Planning Application No: 3/2026/0165

Proposal: Proposed erection of detached garage/carport.

Location: 1 Cockleach Cottages Chipping Road Longridge PR3 2NB

JB 2119
 SITE/ROOF PLAN PROPOSED 1:500 REVISION A
 SHOWING NEAREST TREE

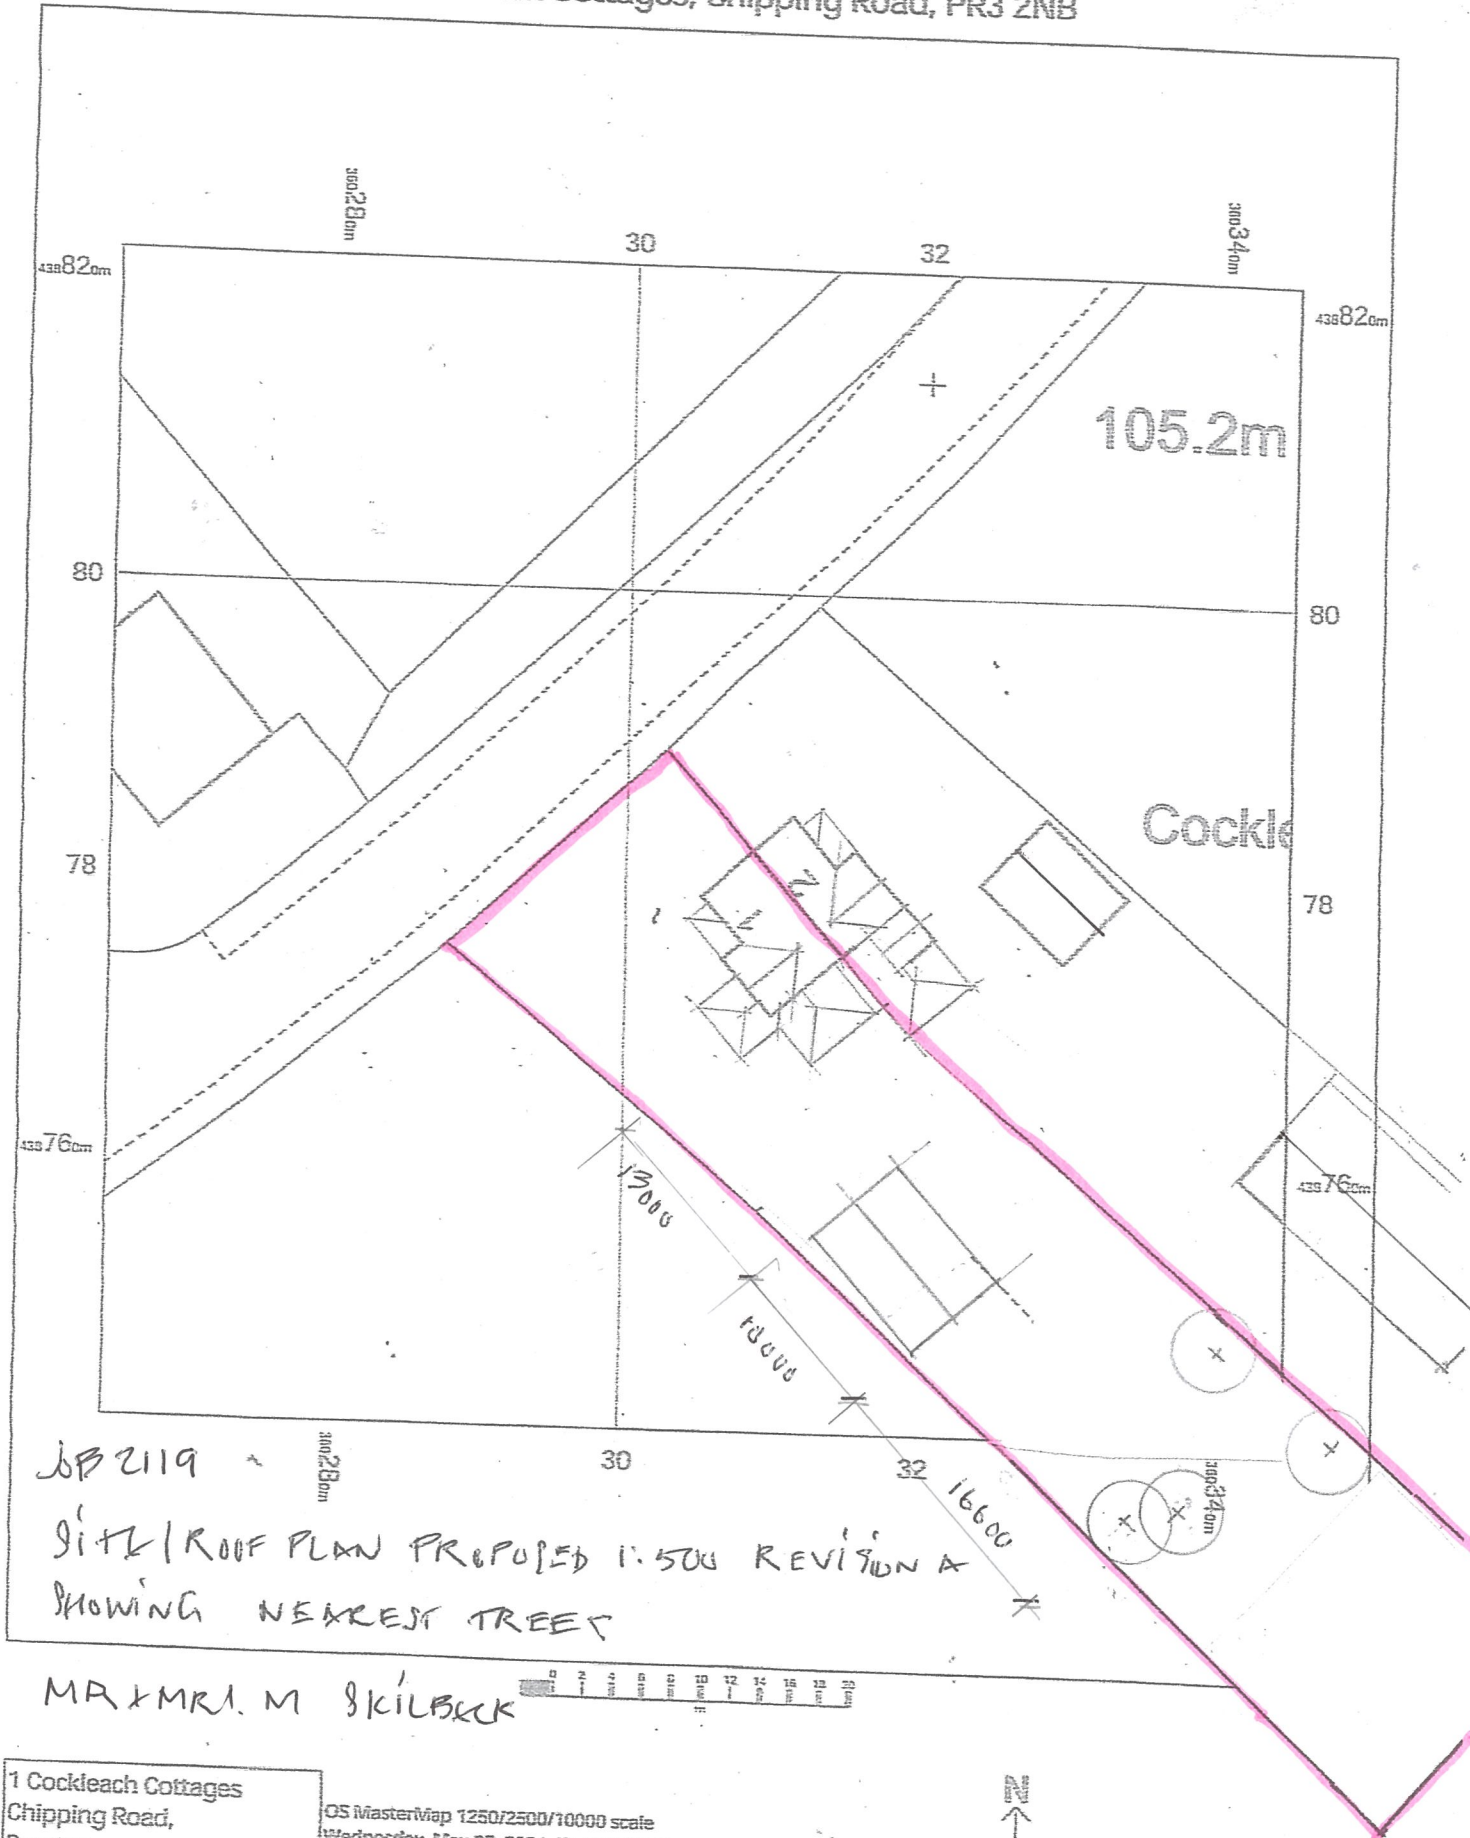
- The parking area must be constructed of a bound porous material and created before first occupation up until the lifetime of the garage/car port existing in its proposed state. Reason: To ensure that satisfactory parking is provided before the proposal hereby permitted becomes operative.
